Written summaries of oral representations made at Issue Specific Hearing 2 by the Cambridgeshire Authorities

- 1.1 This note summaries the submissions made by Cambridgeshire County Council (**CCC**), Huntingdonshire District Council (**HDC**) and South Cambridgeshire District Council (**SCDC**) (together, the **Cambridgeshire Councils**) at the Issue Specific Hearing on 23 September 2021 (the Hearing) in relation to the application for development consent for the A428 Black Cat to Caxton Gibbet Road Improvement Scheme (the Scheme) by Highways England (the Applicant).

TOSELAND ROAD - SUBMITTED SCHEME PROPOSALS

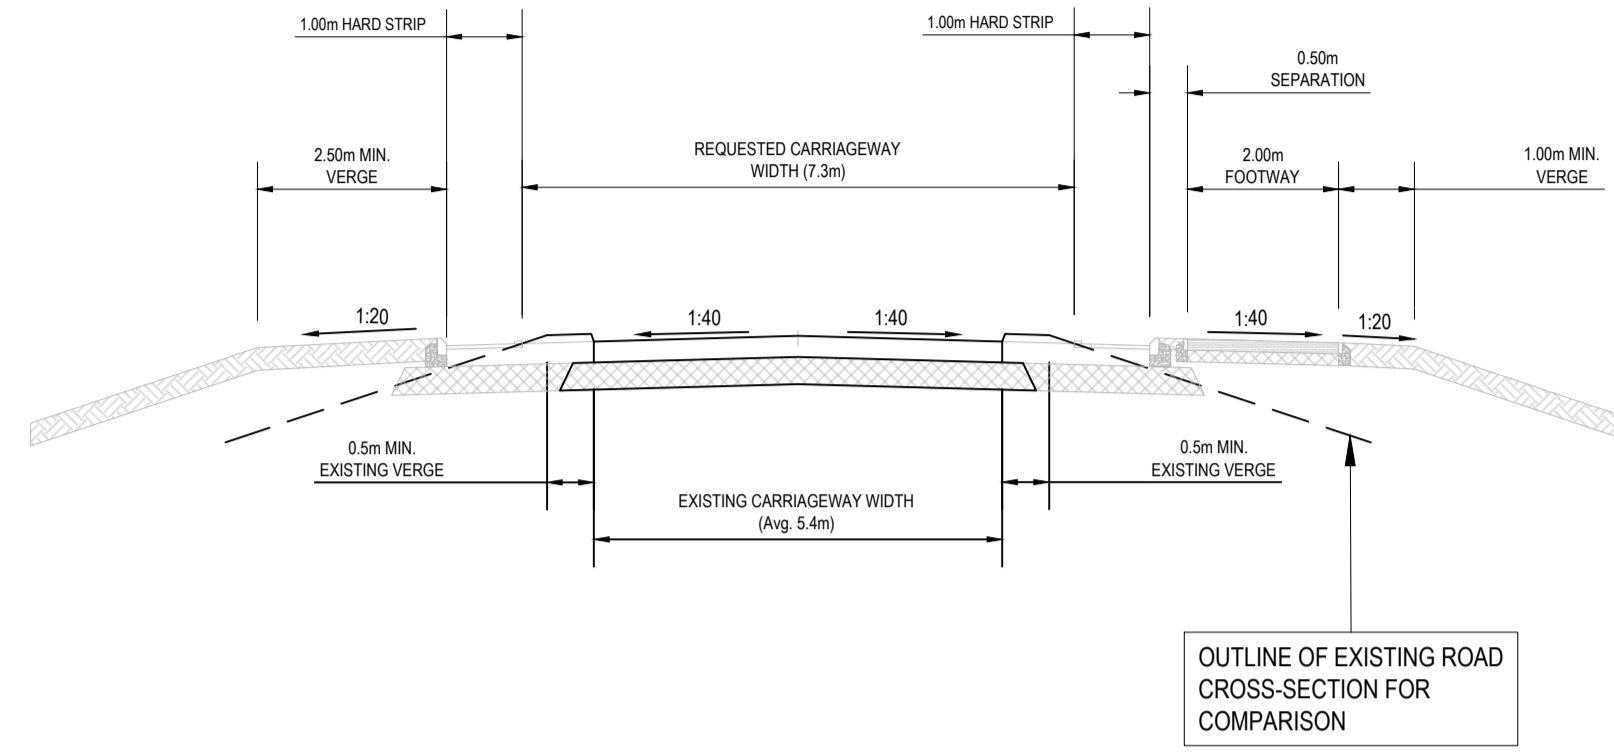
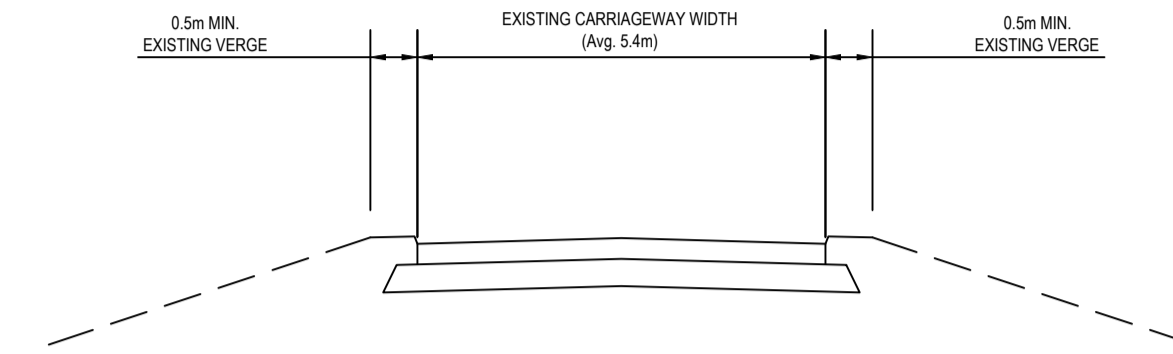
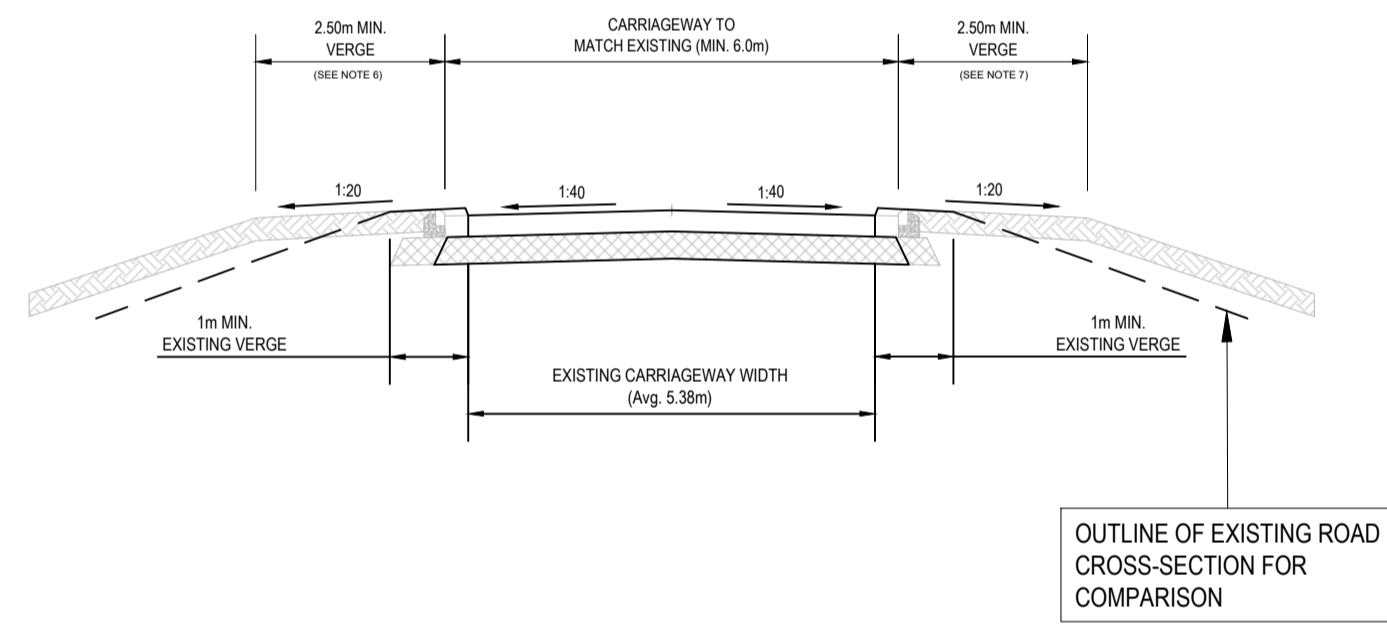
Mr Mitchell confirmed that the main points are set out in the Written Representation.
iii. Toseland Road	The ExA noted CCC's concerns as set out in section 4.11.2 of the Written Representation [REP1-048]. Mr Mitchell confirmed that the main points are set out in the Written Representation.
iv. Caxton Gibbet services access	The ExA asked CCC whether there were any matters CCC wished to raise on this point. Mr Mitchell confirmed that he was not aware of any particular points to raise on this matter.

POTTON ROAD - SUBMITTED SCHEME PROPOSALS

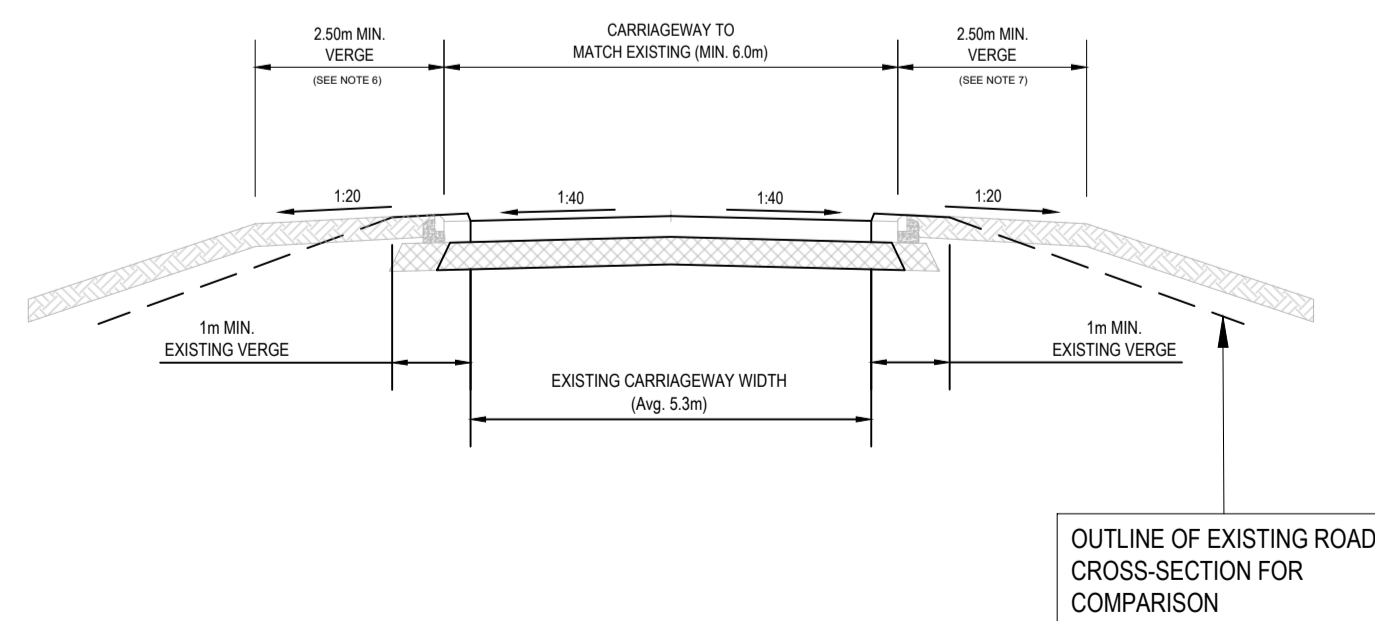
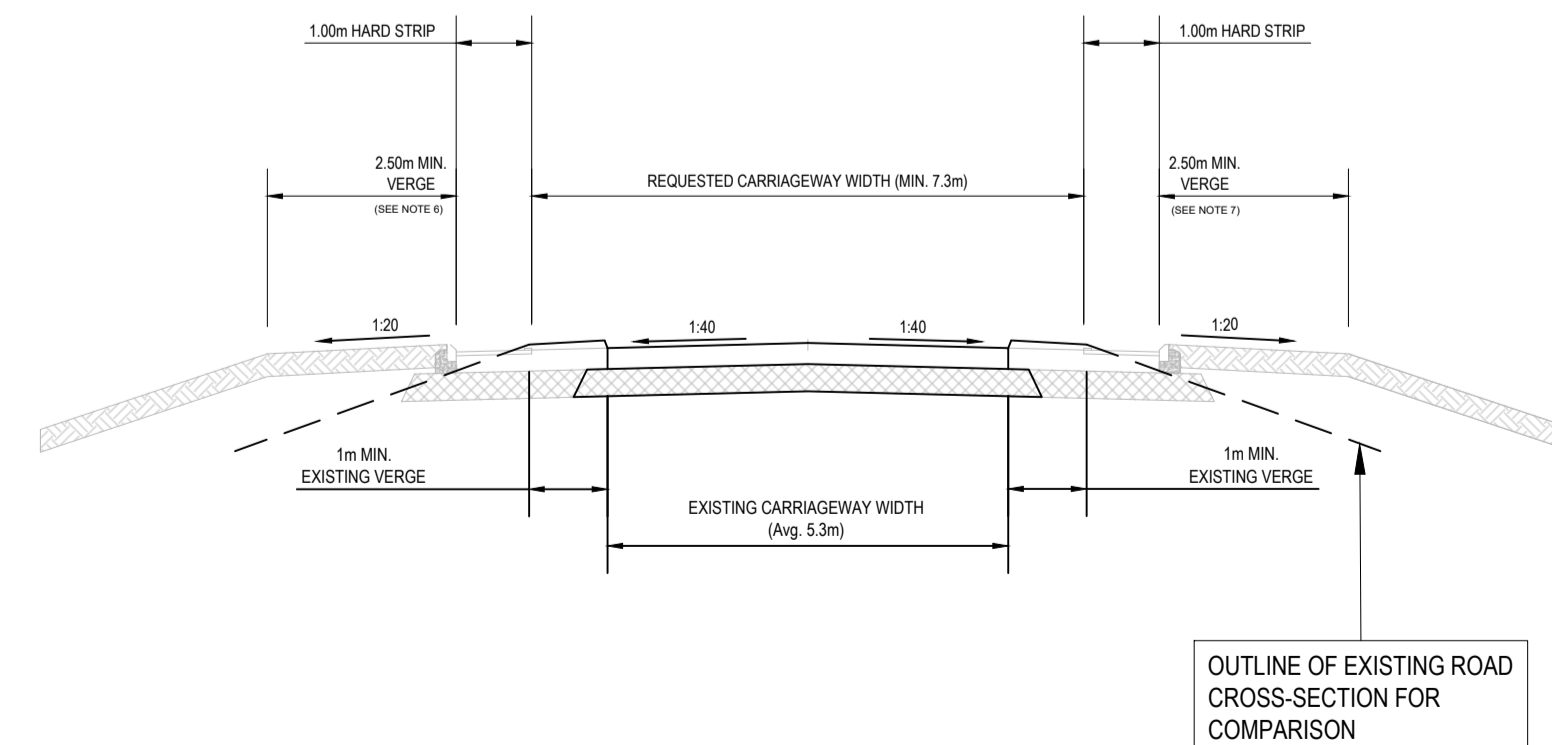
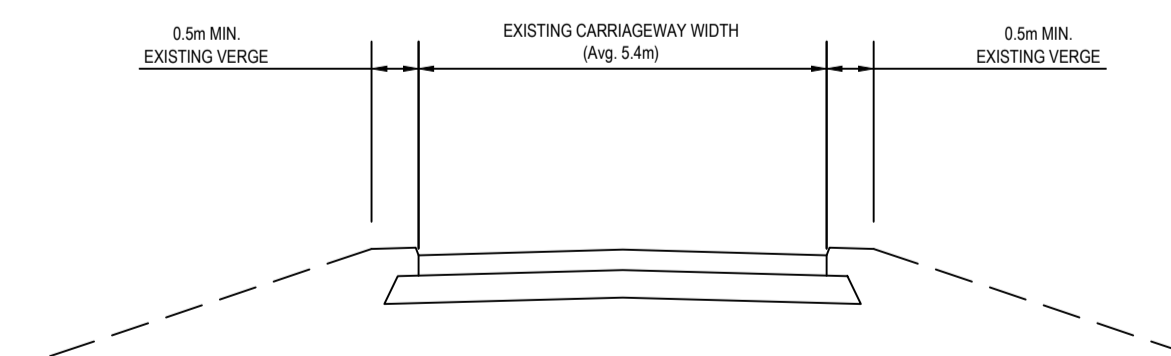
<p>c. Discussion of specific proposed highway arrangements</p>	
<p>i. Potton Road realignment</p>	<p>The ExA noted CCC's concerns as set out in section 4.11.1 of the Written Representation [REP1-048] and asked if there were any elements CCC wished to amplify.</p>

<p>iii. At and along new local highway infrastructure, including Roxton Road Bridge, Barford Road Bridge, Potton Road Bridge, and Toseland Road</p>	<p>In relation to the Potton Road Bridge, Ms Rhodes explained that CCC are seeking safe NMU provision within the verges for the realigned Potton Road which should be able to connect to FP 11 on Sheet 5 of the Streets, Rights of Way and Access Plans [APP-013] as well as to the B road. These roads have a 60mph speed limit and the new T-junction and the bridge will prevent visibility. CCC are seeking safe NMU provision segregated from the road across the new A428 and to futureproof that site for future potential to link in to cycle network improvements in that area as well as to the wider ROW network. This would make the route compliant with CCC's ROWIP statements of action.</p>

<p>CCC notes that the Applicant is to provide further information in relation to this matter at Deadline 3.</p> <p>In relation to the Toseland Road Bridge, Ms Rhodes drew the ExA's attention to Sheet 11 of the Streets, Rights of Way and Access Plans [APP-013]. The current position is that this footway over Toseland Bridge is shown as a footway only, whereas previously this was shown as a shared use route in earlier iterations of the design and appears to have been downgraded. Ms Rhodes emphasised that this route needs to be an all-inclusive route to allow cyclists to continue north with a suitable transition from off to on road. South of the bridge, CCC are seeking a crossing to enable safe access to the Abbotsley Road on the south side of the A428.</p> <p>In response to the Applicant's explanation that the existing demand would not justify the upgrading of the status of this route, Mr Tyrrell highlighted paragraphs 315 on the national NN NPS in relation to the commitments to sustainable transport and encouraging modal shift and noted that these presumably align with the Applicant's own net zero ambitions, including net zero for road users. Therefore it is important not to place too much emphasis on current usage if the policy goals of carbon reduction along the road network and modal shift are to be achieved.</p> <p>Ms Rhodes highlighted that CCC's proposal would create an important safe, off-road circular route. In relation to the footpath diversion, CCC recognise that this is necessary however it is a lengthy diversion so it would be good to have some benefit to off-set this. Ms Rhodes highlighted the importance of this corridor and the safe connectivity with the wider network.</p>

Wyboston Junction

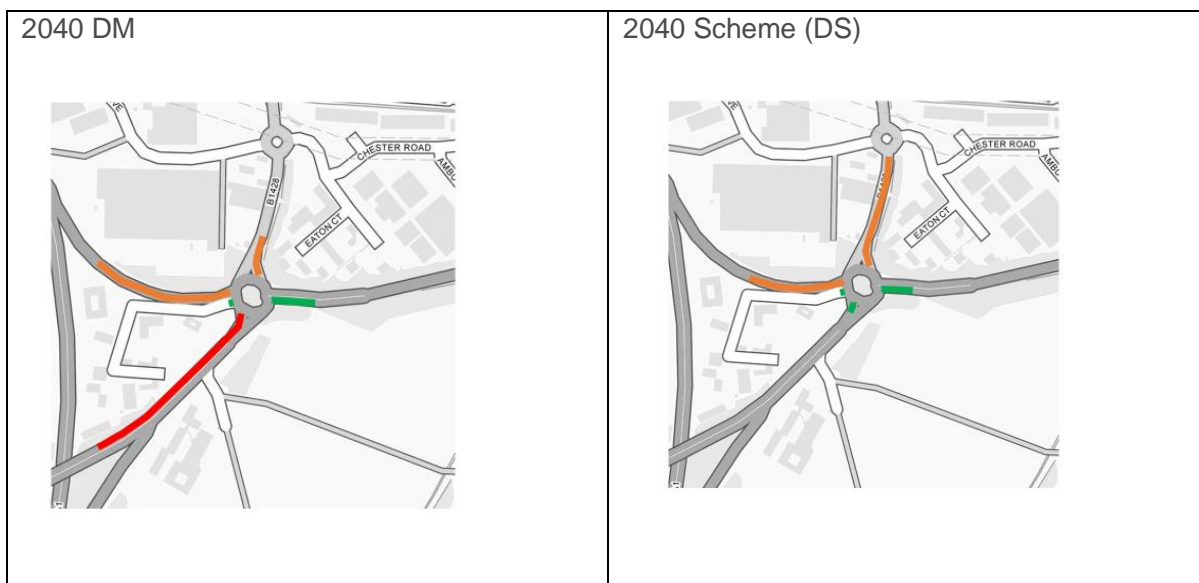
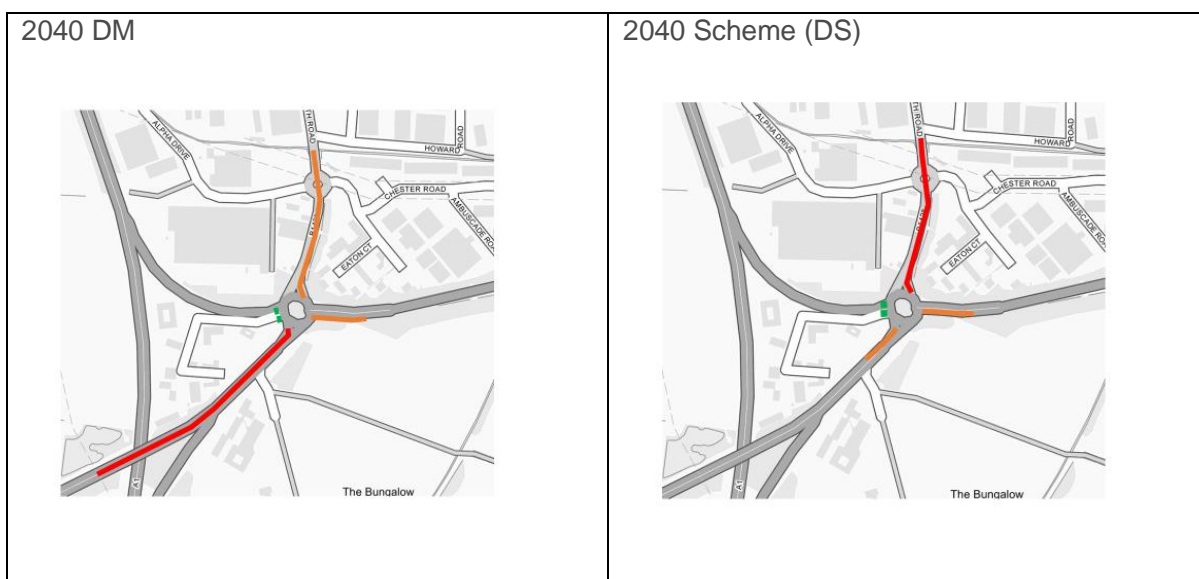
<p>b. Potential impacts at roads and junctions identified in CCC, HDC and SCDC Joint Local Impact Report [REP2-003]</p>	
<p>i. Great North Road, St Neots</p>	<p>The ExA asked CCC what it considers to be the impact of the modelling with a view to understanding whether the difference would be a few cars lengths in a peak time queue or the fundamental functioning of the junction or highway.</p> <p>Ms Mason-Walsh explained that the issue at Wyboston Roundabout is that the Great North Road arm is shown to perform worse and it is predicted to have a 200 passenger car unit (PCU) increase in traffic flows at both</p>

<p>the AM and PM peak periods. That arm of that junction historically saw long queues which regularly backed past the adjacent junctions and as such CCC have asked for the adjacent junctions between Nelson Road and Wybston Road on the Great North Road to be assessed. The re-routing is a direct result of the scheme and without confidence that the intermediate junctions can work, there is a risk that the re-routing might not be secured away from the town centre. Several of the junctions are small mini-roundabouts and they would struggle to accommodate additional traffic as a result of the scheme. CCC has asked for the Wyboston Roundabout to be modelled using the best practice methodology because a count does exist for that junction, which would give greater confidence in the performance of the actual Wyboston Roundabout and then subsequently CCC has asked for the intermediate junctions to be assessed so that CCC can have confidence that the Great North Road can accommodate the additional traffic that the strategic model is suggesting will re-route away from St Neots town centre.</p> <p>The ExA requested clarification that CCC require more confidence in the information that it has been provided with rather than coming straight to the conclusion that the scheme is going to cause difficulties with that arm of the junction. Ms Mason-Walsh confirmed that this was the position.</p>
